KITTITAS COUNTY COMMUNITY DEVELOPMENT SERVICES

Subject: PD-16-00001 & LP-17-00004 Carrier Heights PUD & Preliminary Plat Additional Information Required

SHEET CONTENTS
SITE PLAN

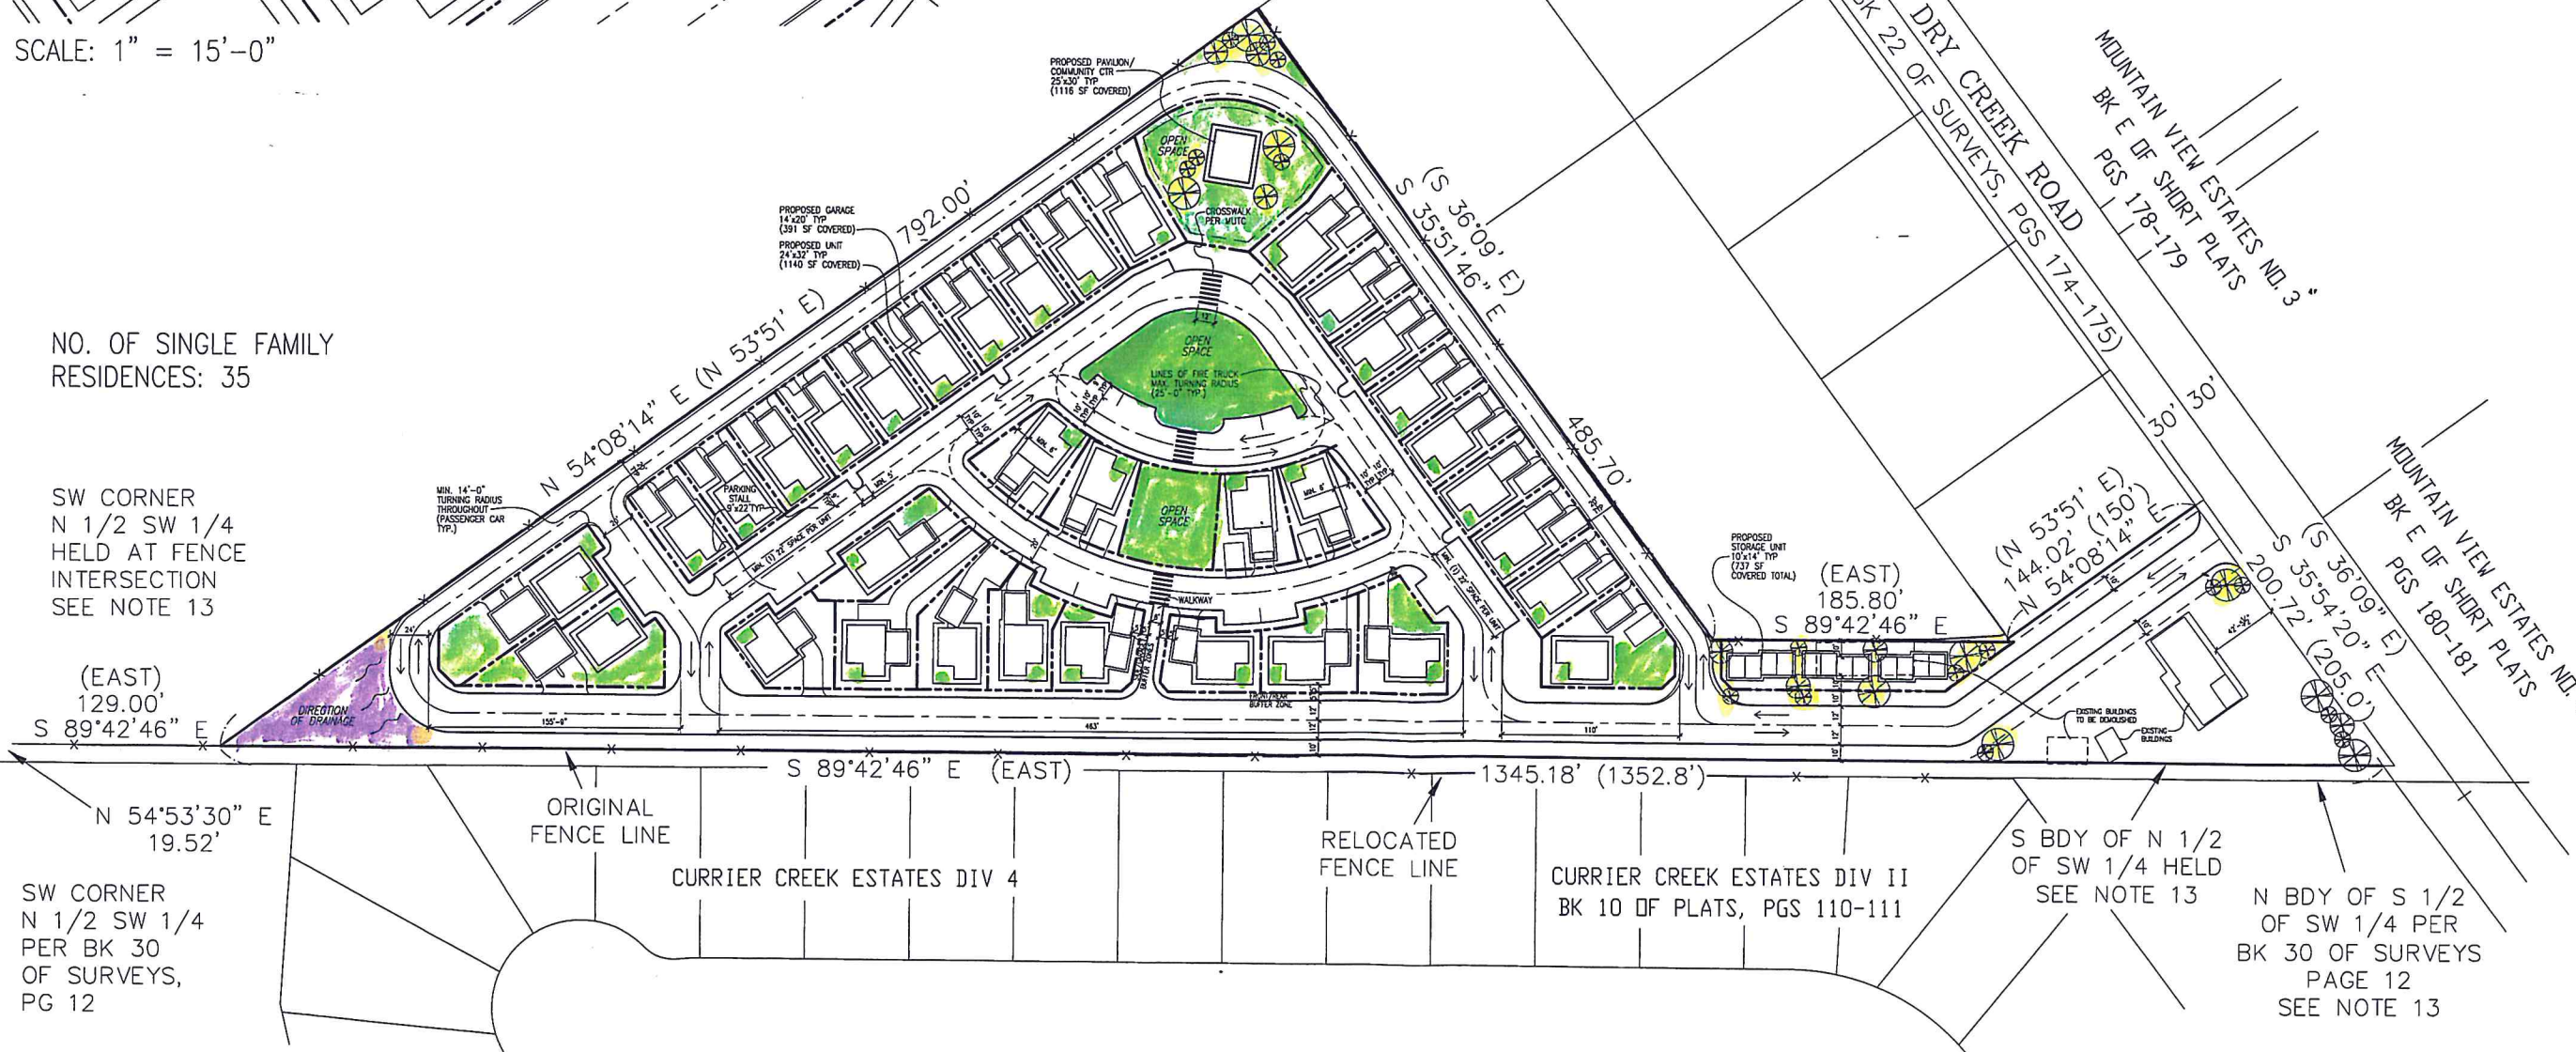
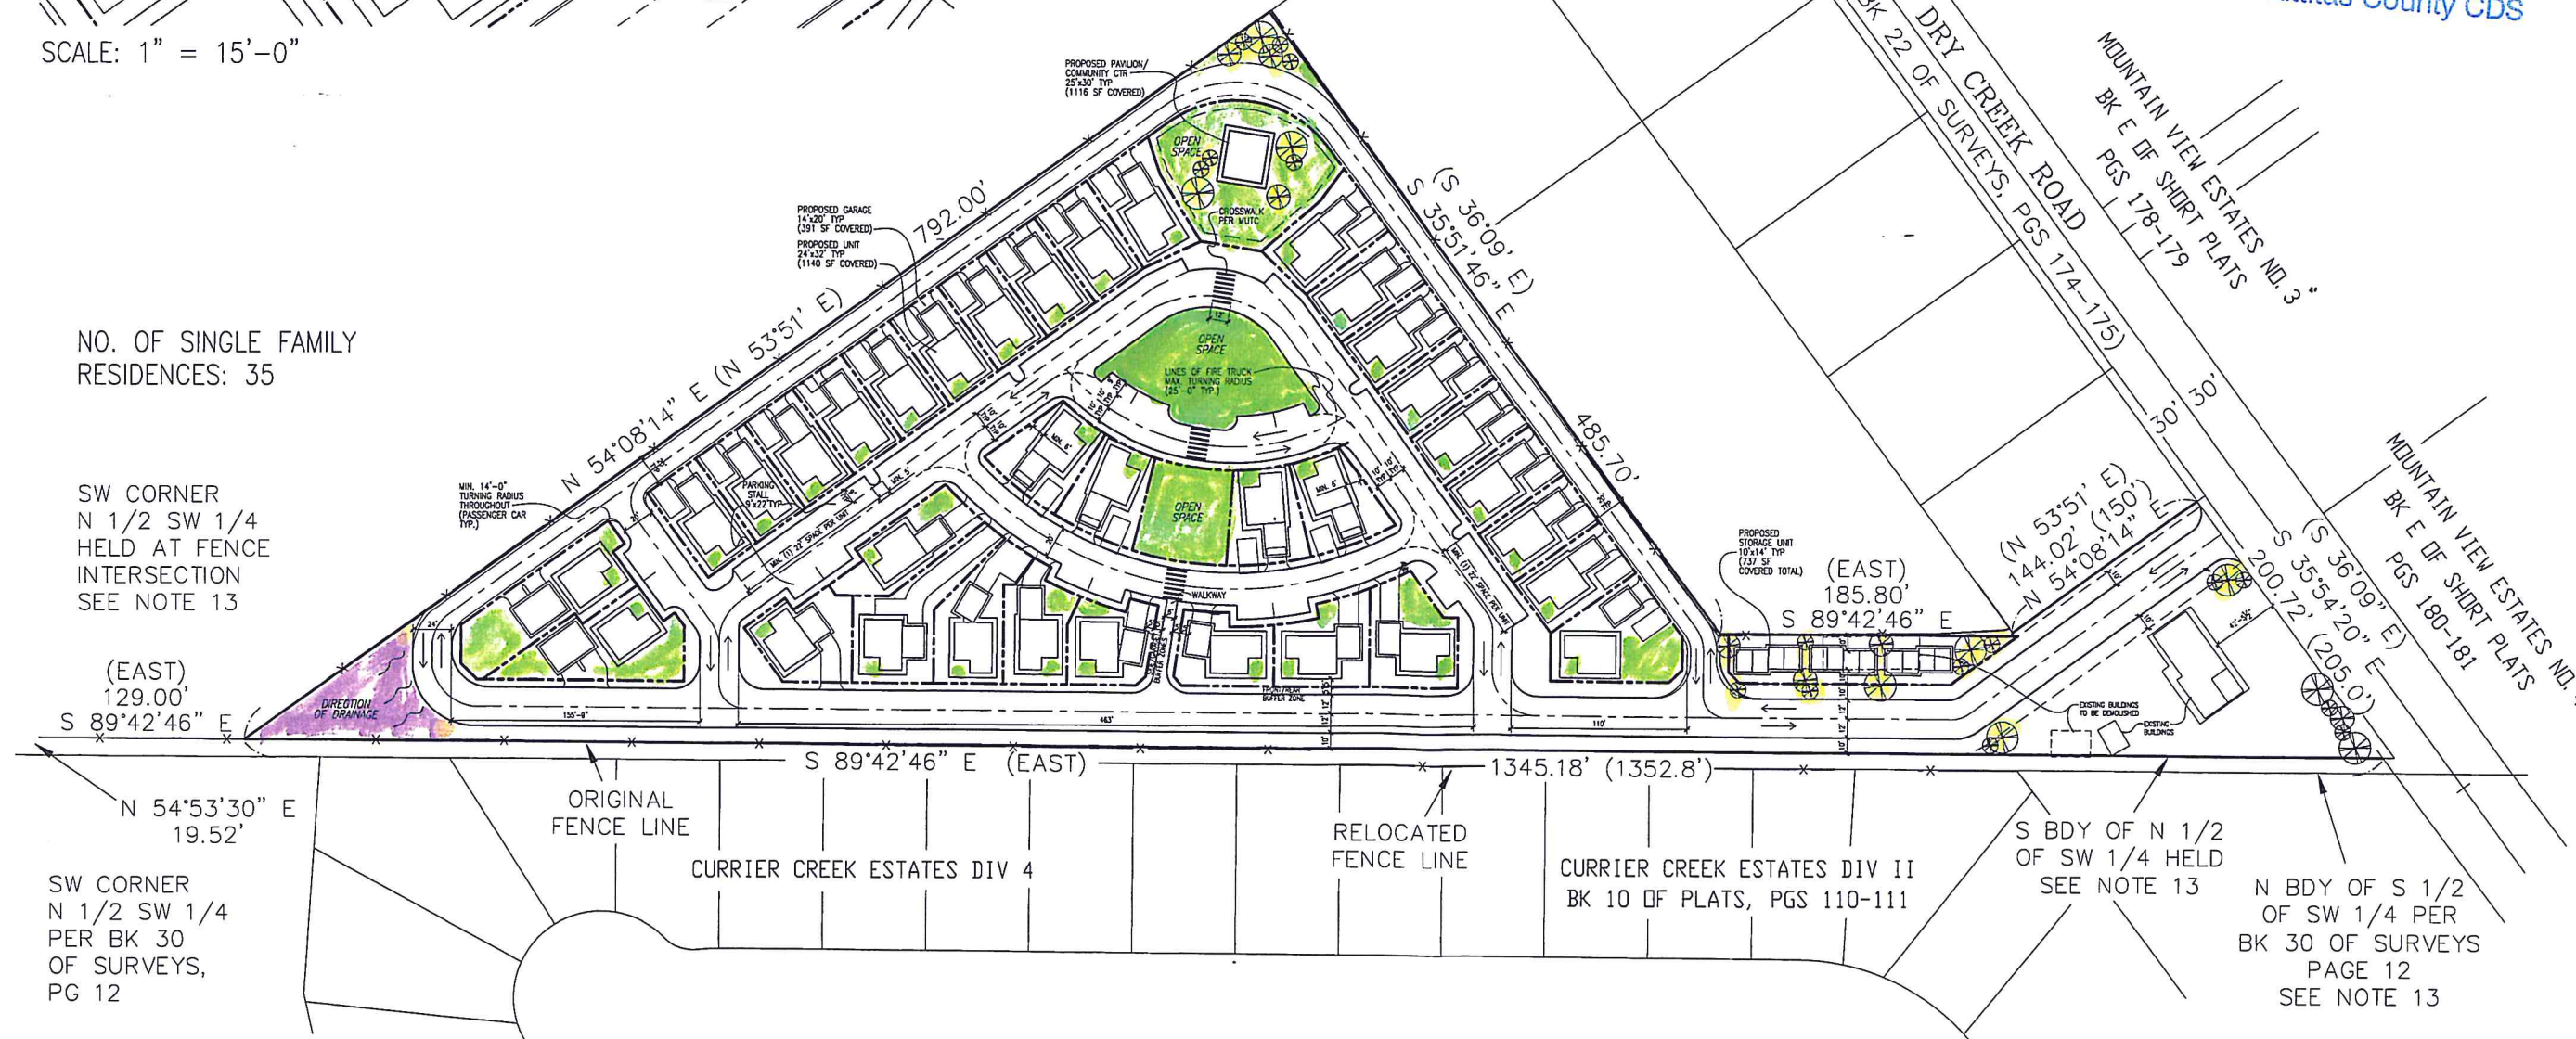
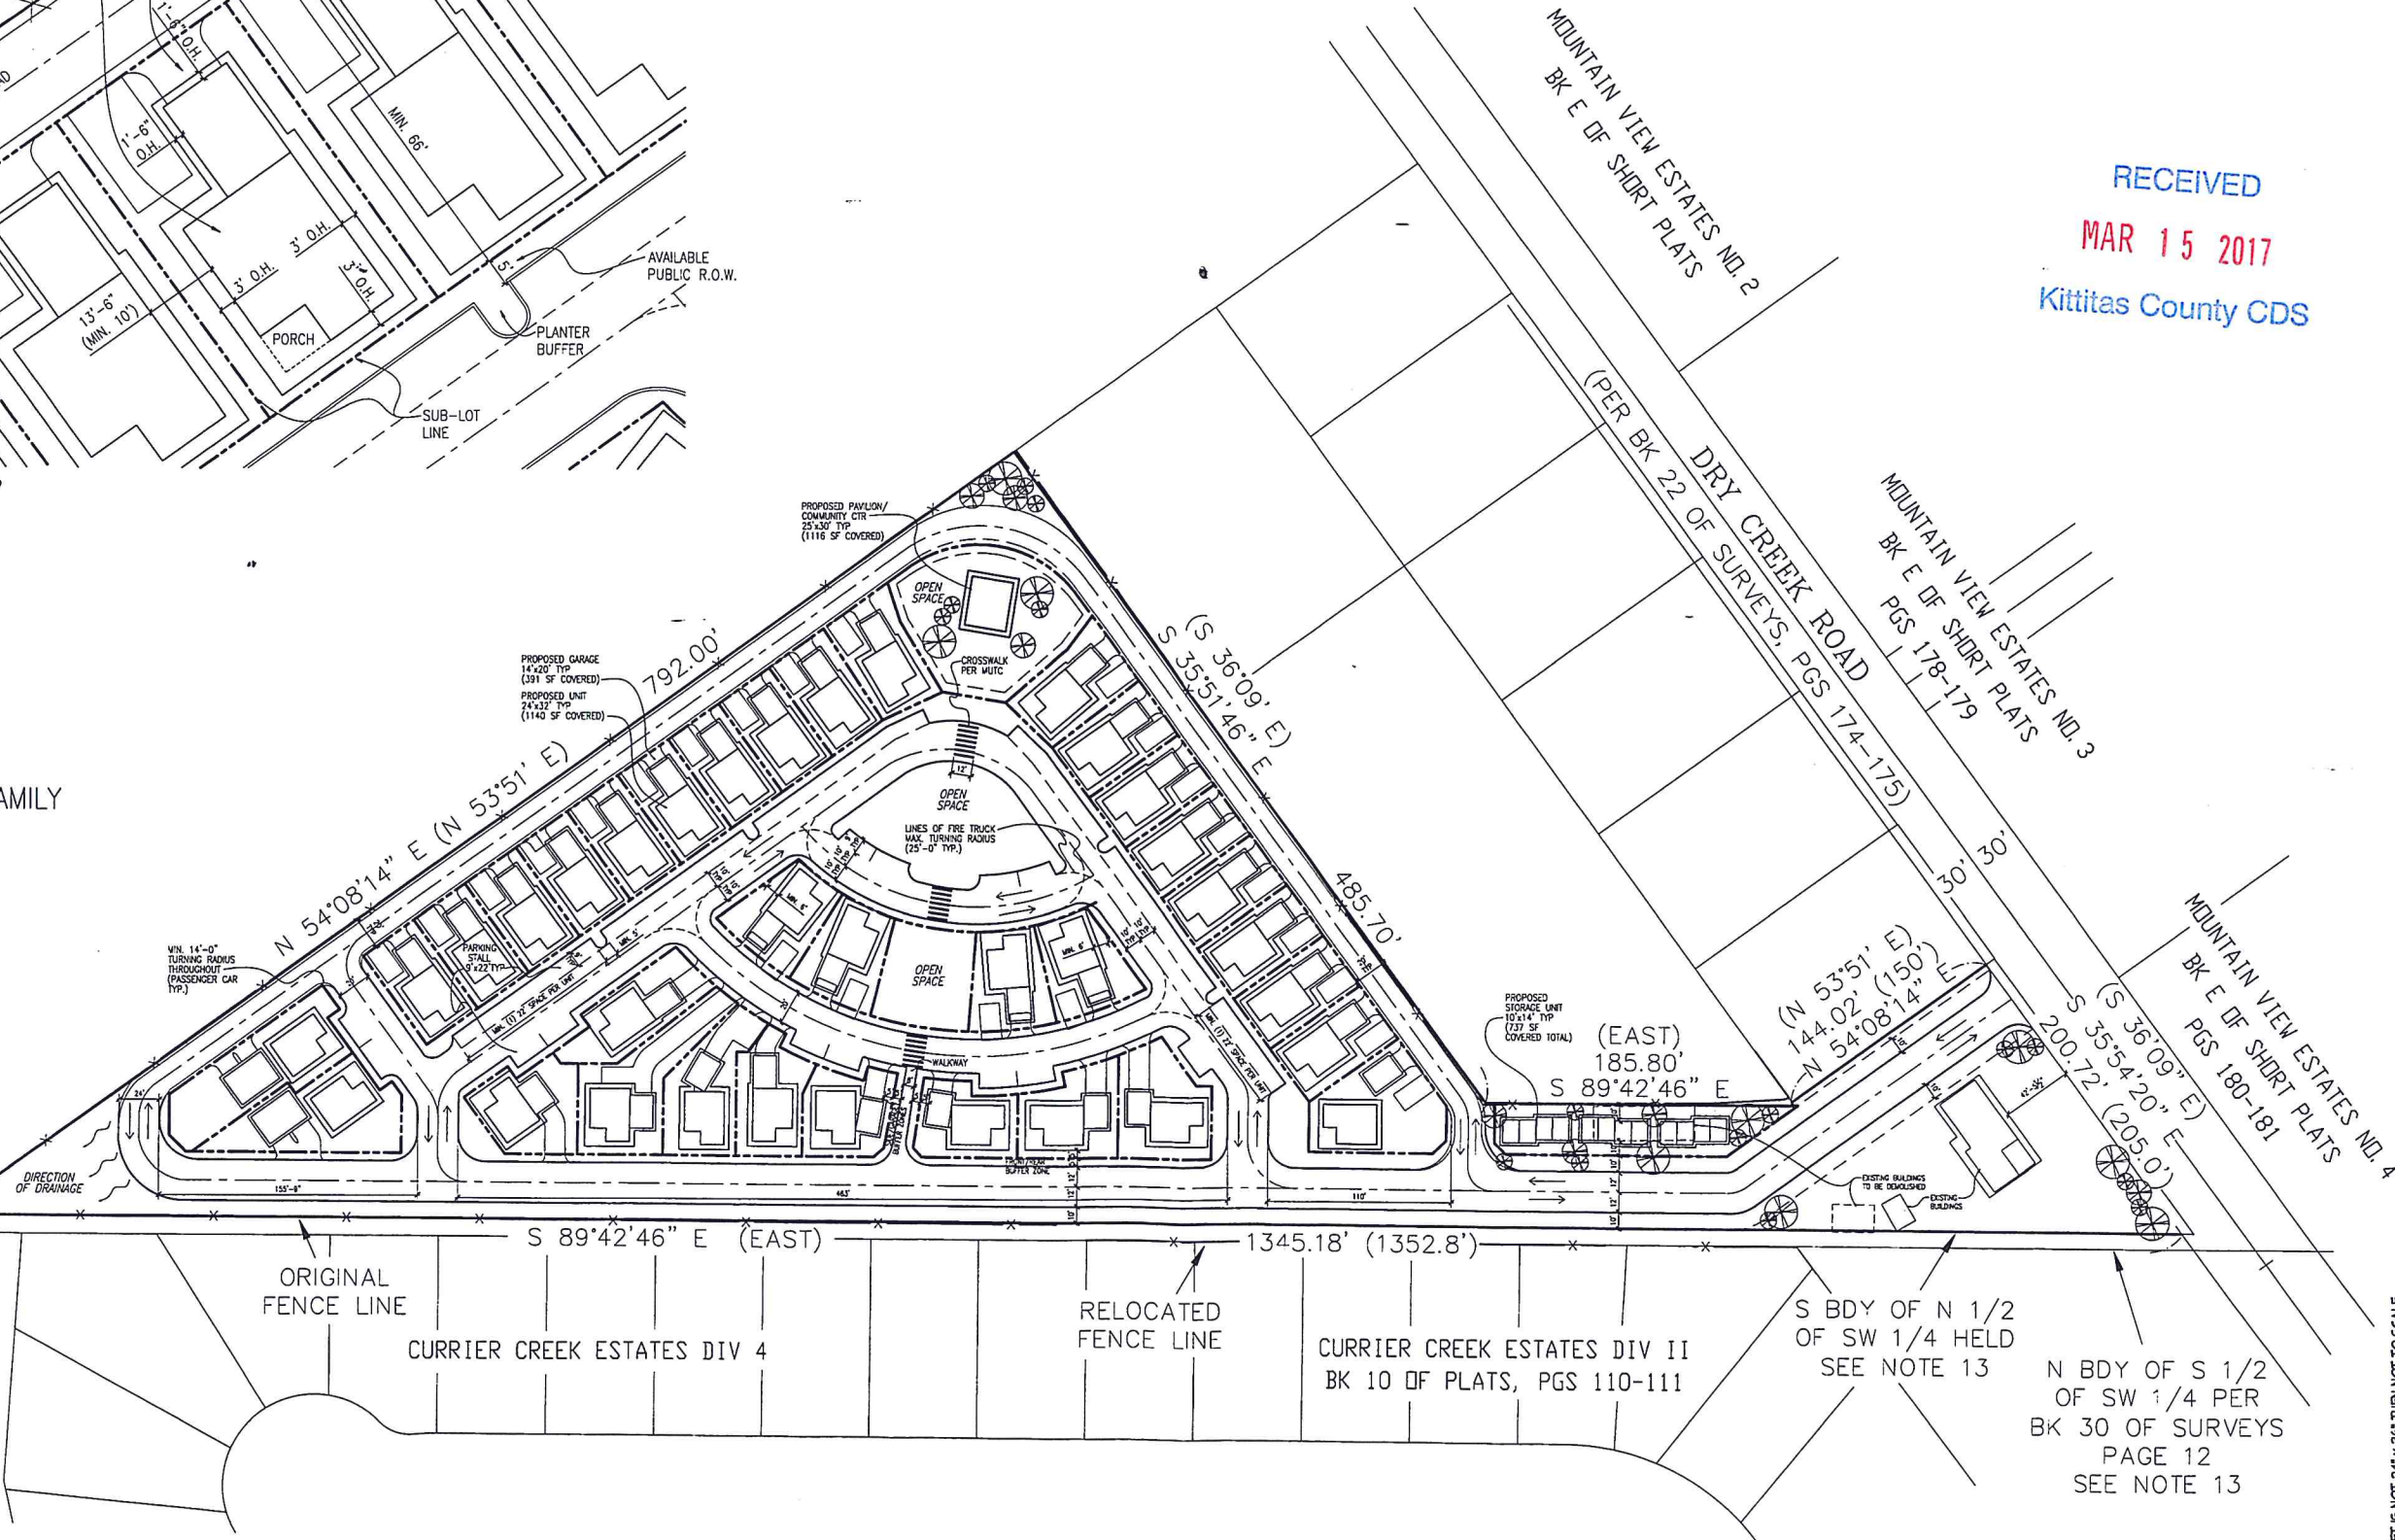
2. KCC 17.36.030 requires a preliminary development plan for the zone change application. KCC 16.12.020 requires preliminary plat drawings for the preliminary plat application. The preliminary development plan submitted with the PUD zone change application is not consistent with the preliminary plat drawings submitted with the preliminary plat application. Therefore, please submit consistent development plan and preliminary plat drawings.

3. KCC 17.36.030(4)(D) requires critical areas and natural features be shown on the preliminary development plan. According to the National Wetland Inventory, the site contains wetlands, which are not shown on the development plan. Please revise the preliminary development plan to show critical areas and natural features.

4. According to KCC 17.36.030(6), a phasing plan is required with identified timelines. The development plan shows phasing, but no explanation is provided. Therefore, please provide a phasing plan with required timelines.

10. KCC 16.12.030(3) requires the location of all existing ditches apparent or of record, marshes, areas subject to flooding, and direction of all watercourses to be shown on the preliminary plat. Therefore, please submit a revised preliminary plat that includes this information.

11. According to KCC 16.12.030(6), the total acreage and total number of lots within the proposed subdivision shall be indicated on sheet one of the plat. Please submit a revised preliminary plat that includes total acreage and total number of lots.
